**Wilpinjong Extension Project (SSD 6764)
Review of Environmental Impact Statement**

The Department of Industry, Skills and Regional Development, Division of Resources & Energy (the Division) has reviewed the *Wilpinjong Extension Project Environmental Impact Statement* and provides the following comments which are directed at specific areas of the Division's responsibility for this proposal.

Figure 1: Revised Post-Mining Landform

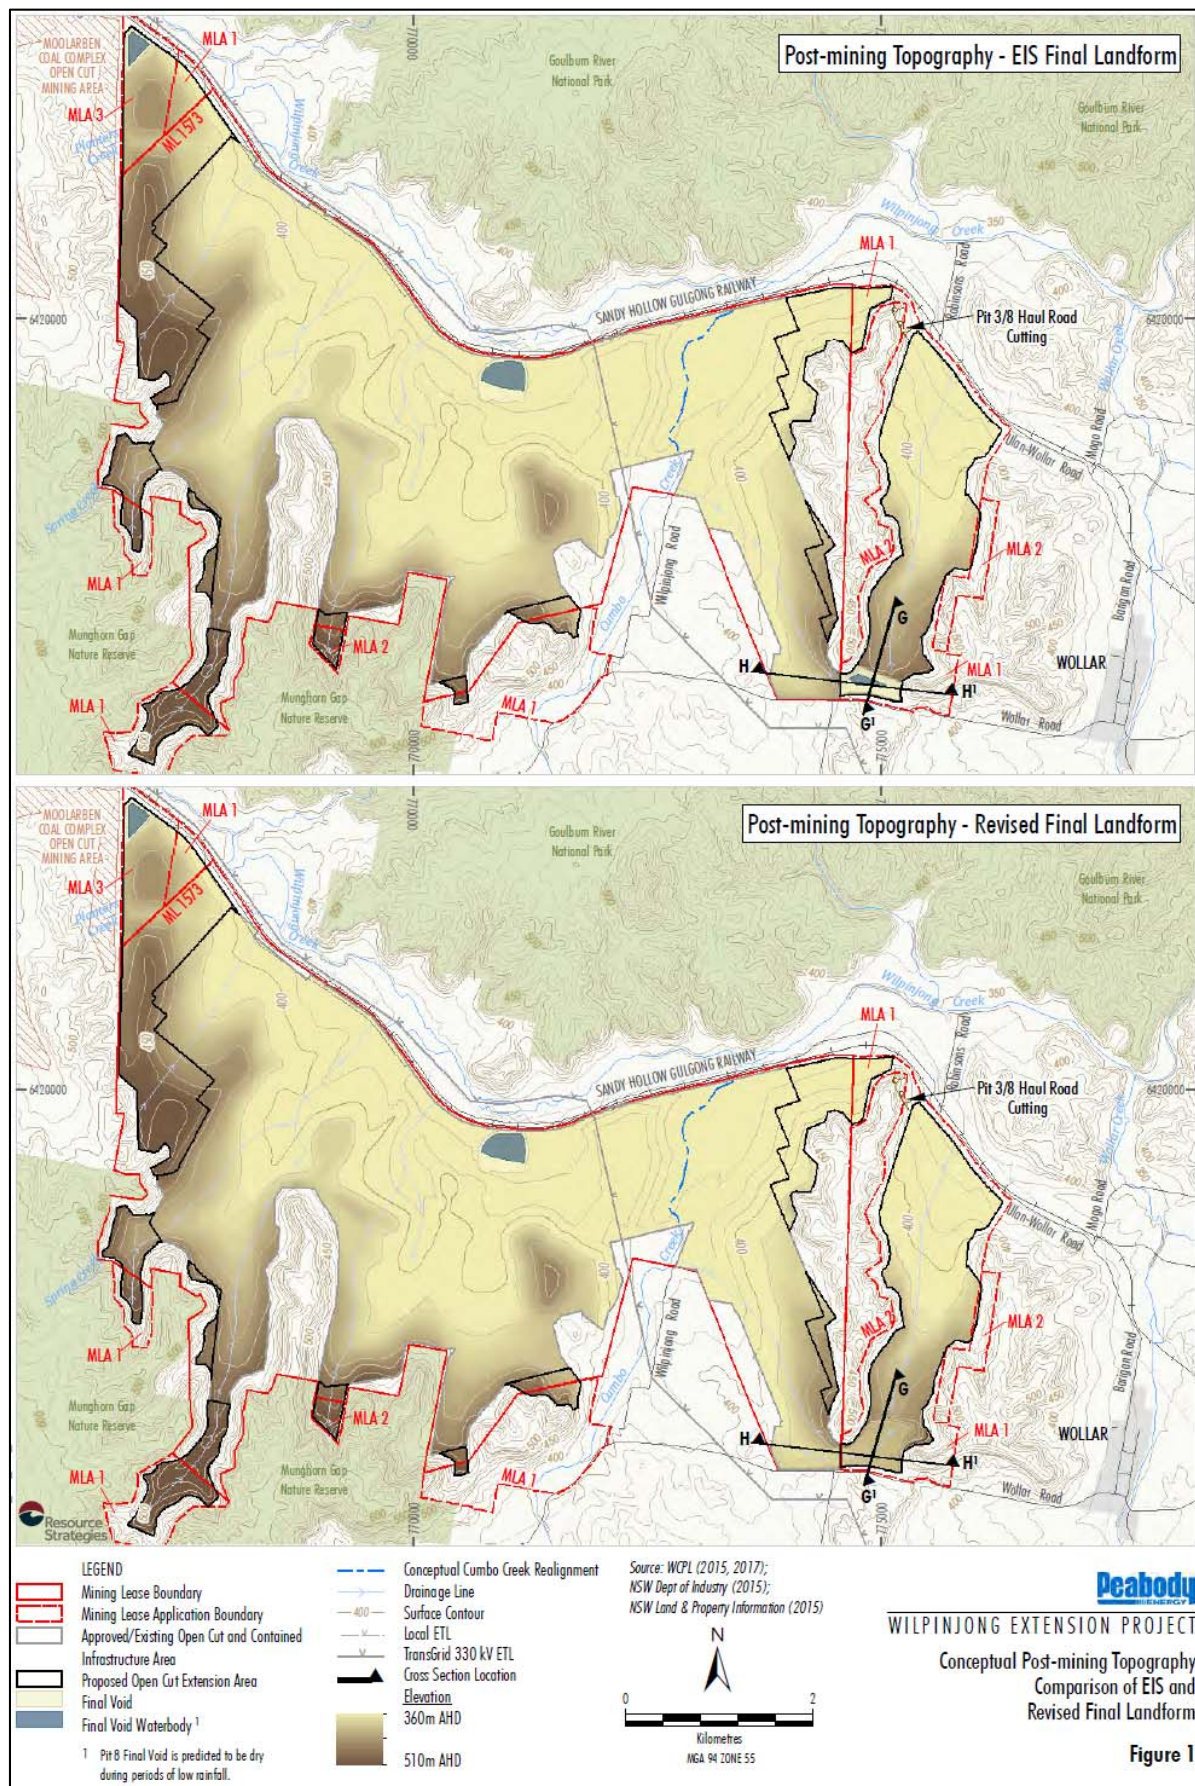
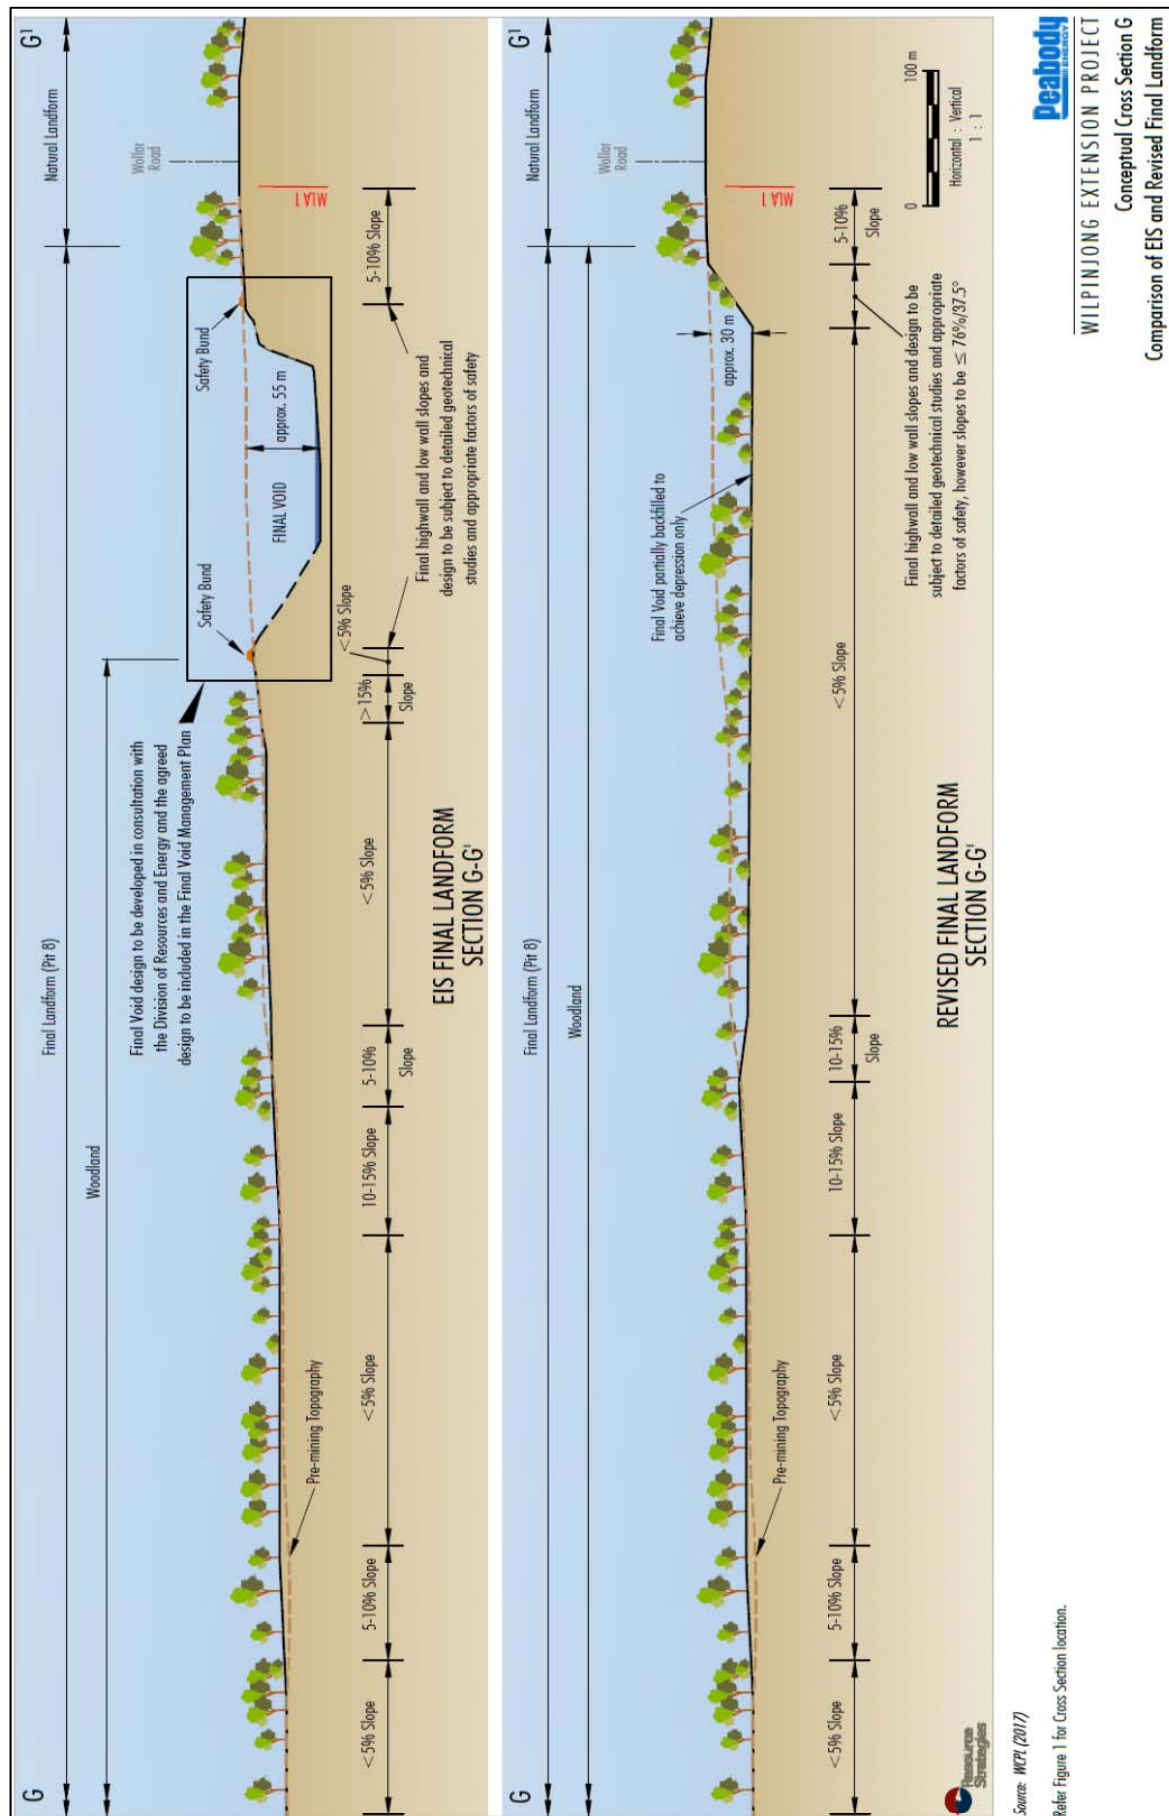
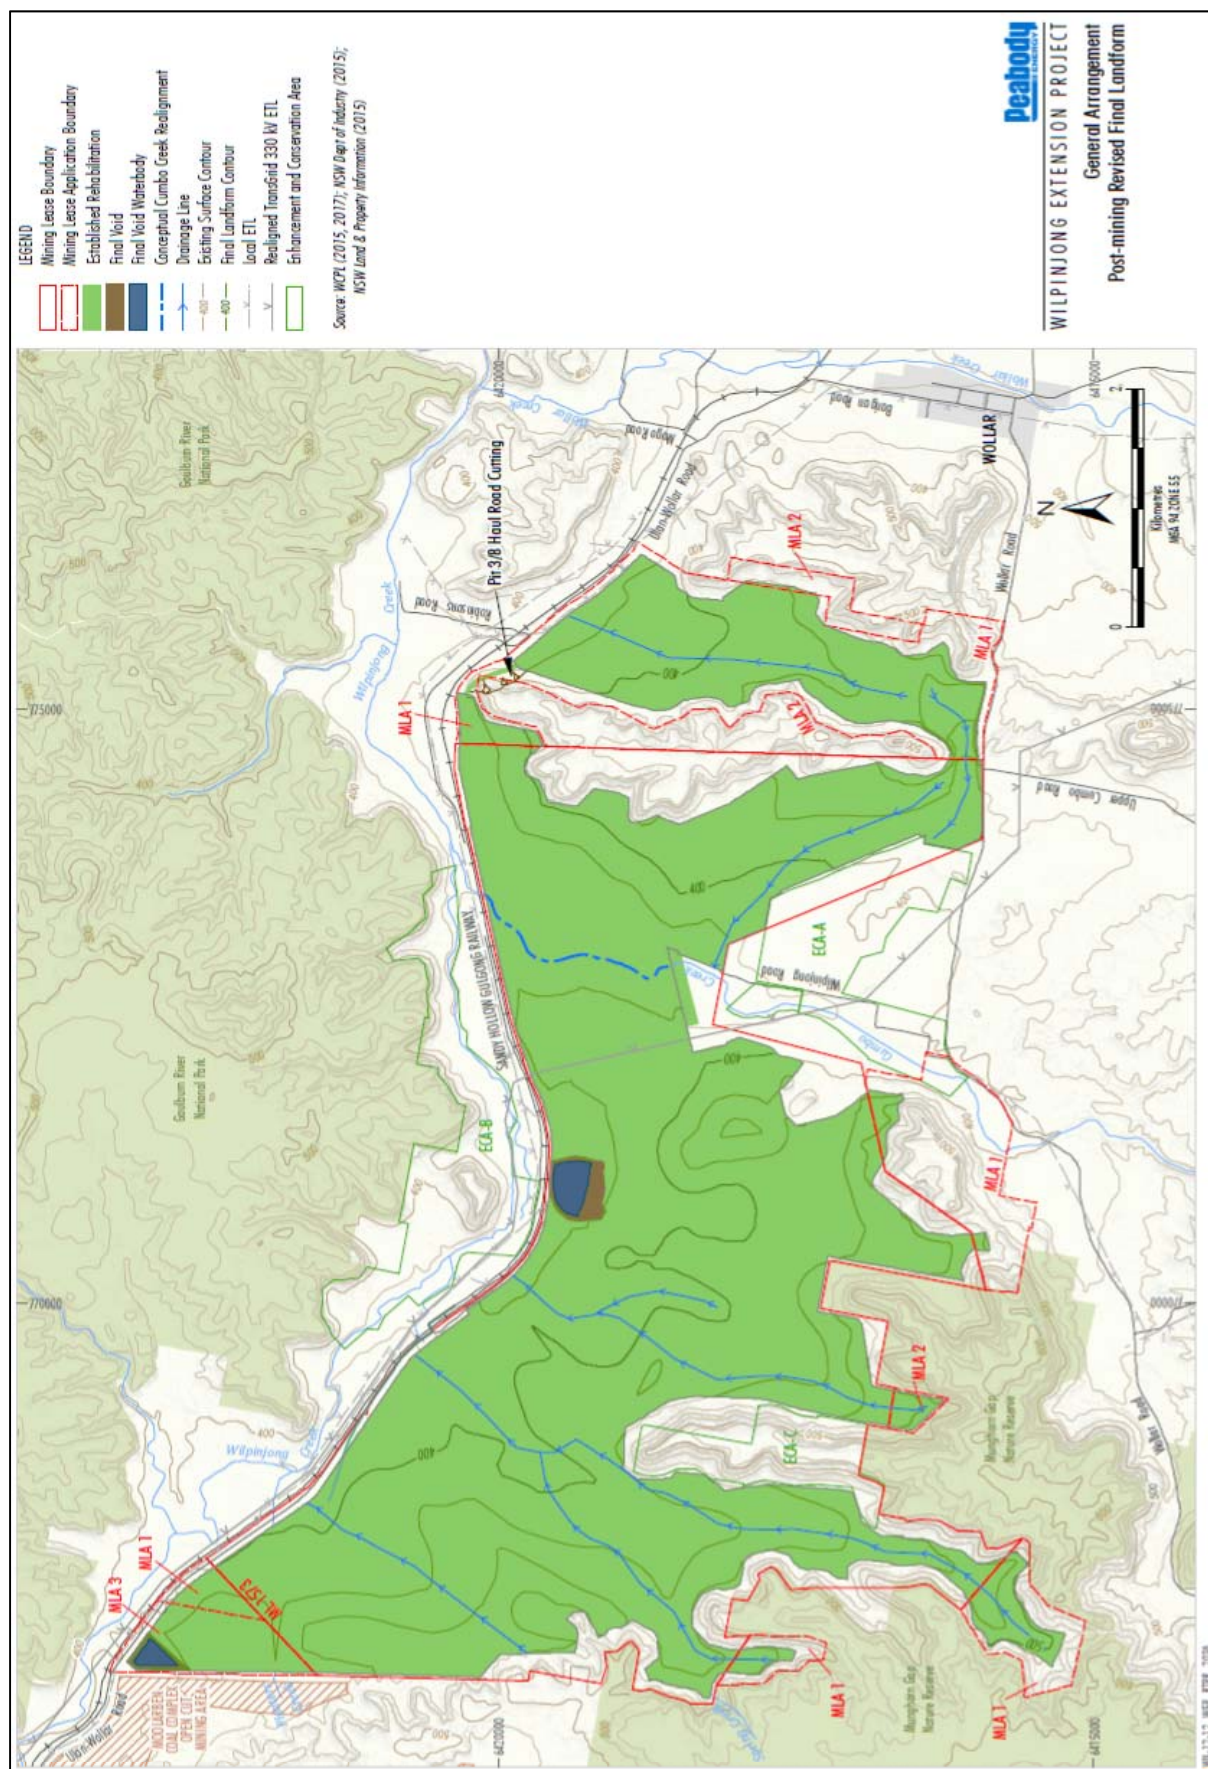
- The EIS lacks the level of specific detail to provide an adequate assessment as to whether the landform design presents a potential barrier or limitation to achieving a sustainable rehabilitation outcome.
- Post-mining landform drawing and cross-sections is not at an appropriate scale to identify key attributes of the final landform (Figures 5-2, 5-4 and 5-5). Contour intervals cannot be defined to establish whether final landform will be capable of supporting the intended final land use(s).

2. Further detail in regards to final landform design, including the provision of drawings and cross-sections at an appropriate scale. Key questions to be addressed include:

- How have similar landscape features as evident in surrounding landscapes been incorporated into the post-mining landform design?
 - Are there any significant geotechnical risks associated with the final voids that may compromise the ability to achieve success closure?

- Will there be any stability issues associated with the final landform in regards to its ability of sustaining the intended final land use (e.g. grazing)?
